Application for Planning Permission for Works or Extension to a Dwelling

Development: Proposed detached triple garage and extended driveway
Location: 160 Littlehampton Road Ferring BN12 6PH

PROPOSED BLOCK PLAN

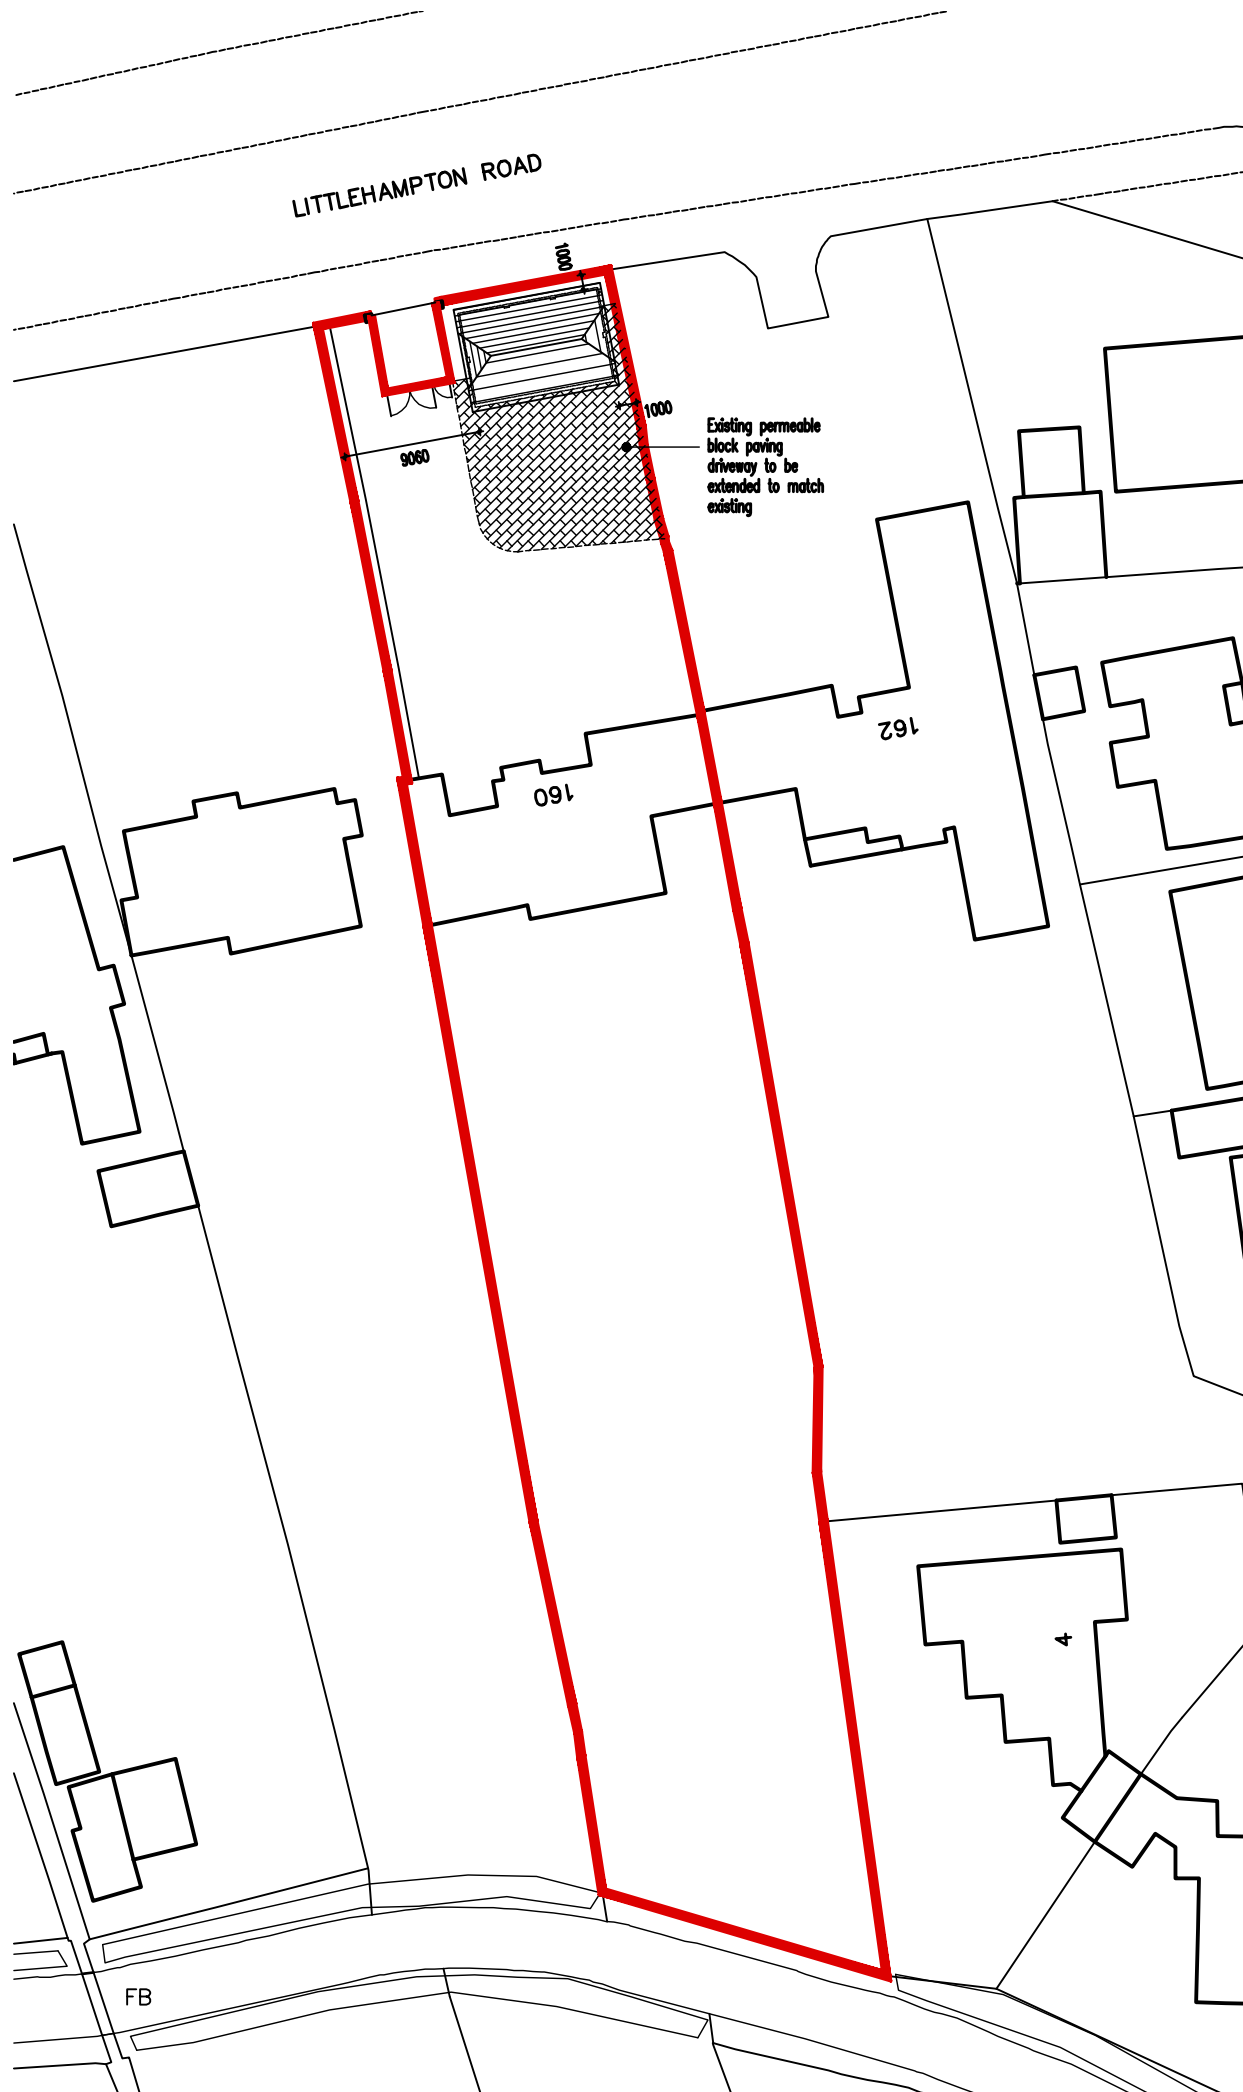
The new gates shown on the block plan require elevation plans.

The location and block plans are inconsistent, there is a small outbuilding behind the dwelling on the block plan which cannot be seen on the location plan.
